**Comments on the additional submission for Planning Application-
6/2018/2768/OUTLINE to build 1100 homes in Ellenbrook Fields,
by Cllr Margaret Eames-Petersen
(Hertfordshire County Councillor for Hatfield North Division)**

Objection

These comments are directed at the addenda that have been added to the Environmental Impact Assessment submitted by Arlington on the following:

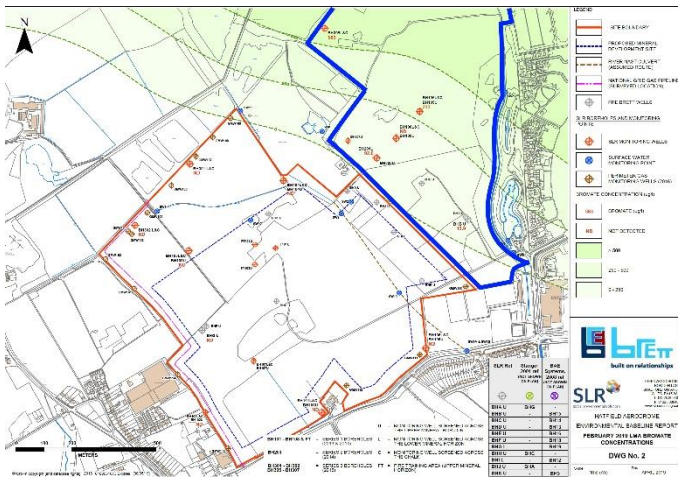
- that the interburden (clay barrier) is the only protection of the primary and secondary aquifers. The clay interburden thickness is cyclic in nature, and not a consistent thickness. It does not give adequate protection to the underlying primary aquifer.

My objection is that a thorough investigation of the site has not yet been conducted:

- Insufficient boreholes have been sunk to determine the depth & thickness of the interburden and the depth of chalk aquifer – only three boreholes CP001/3/2 are sunk to a depth of 6 m, 12.5 m, 14.5 m below ground level. These boreholes are of insufficient depth to monitor bromate & bromide.

Fig 3

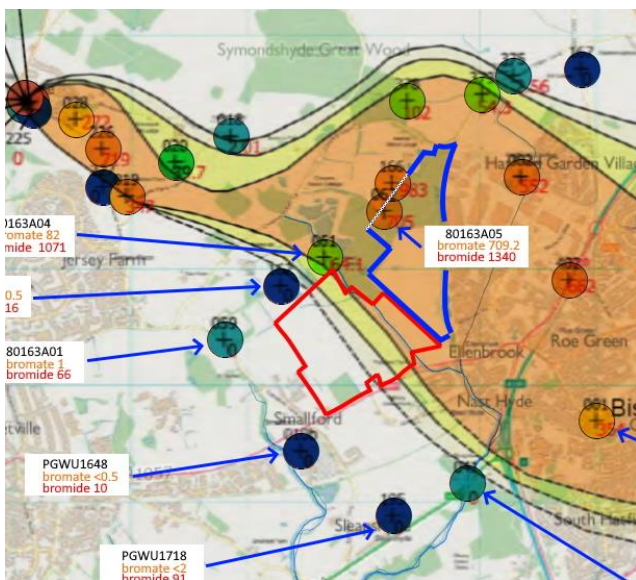
EA plume drawing showing boreholes and housing applicant site. Borehole 80163A05 @ 709.2µg/l bromate is to the West of the housing site.

The EA map is expanded from Part 2A of Environmental Protection Act 1990 St Leonards Court document showing greater than 50µg/l bromate in light red. The site is in the middle of the plume. To the South is the Brett quarry application in red outline.

The site chosen for housing is the most polluted in Hertfordshire, and in direct line for remedial work at Bishops Rise pumping station. Any change in the direction or mobility of the plume could impact on water supplies at Essendon and Roestock. At this stage, it is important to avoid any interference to the chalk aquifer by industrial action required for a housing estate such as digging, piling, redirecting ground water, and flooding the secondary aquifers.

Fig 4

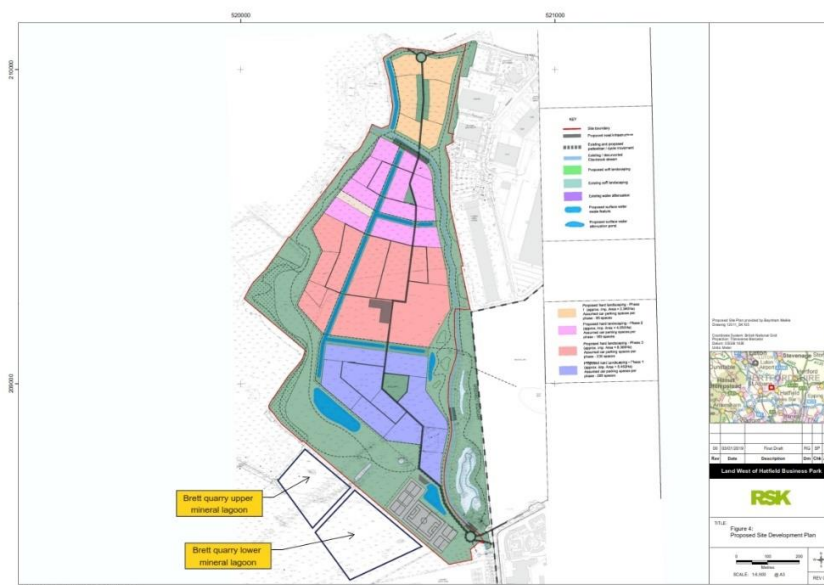
- The cumulative effect of attenuation lakes in the South and Brett quarry infiltration lagoons in the same area was not taken into consideration Fig 4.

Fig 4. shows proposed Brett quarry lagoons in the South. The expected infiltration rate of the Upper Mineral Horizon is estimated at 1,100 to 2,300 cubic metres/day directly into the same ground that the attenuations ponds (blue) would add another 1000 to 2500 cubic metres/day, from the run off from the new development. These totals double the groundwater amount, which is now focused on a specific area potentially leading to flooding downstream of the combined sites.

Fig 5

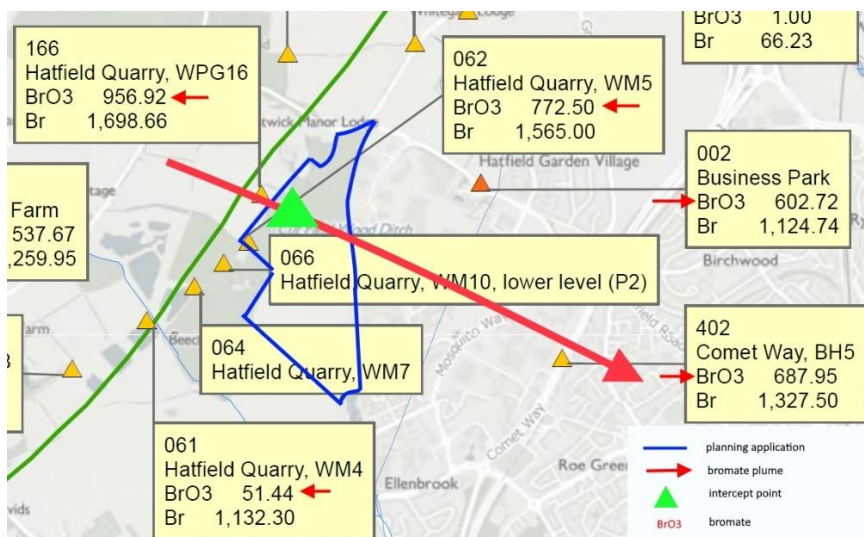
- The objection is that the EA remedial plan using an array of boreholes, perpendicular to the plume and at its highest bromate levels, would require an area to operate that is clear of obstacles and housing.

The intercept point is shown in green. The plume has a S.E direction.
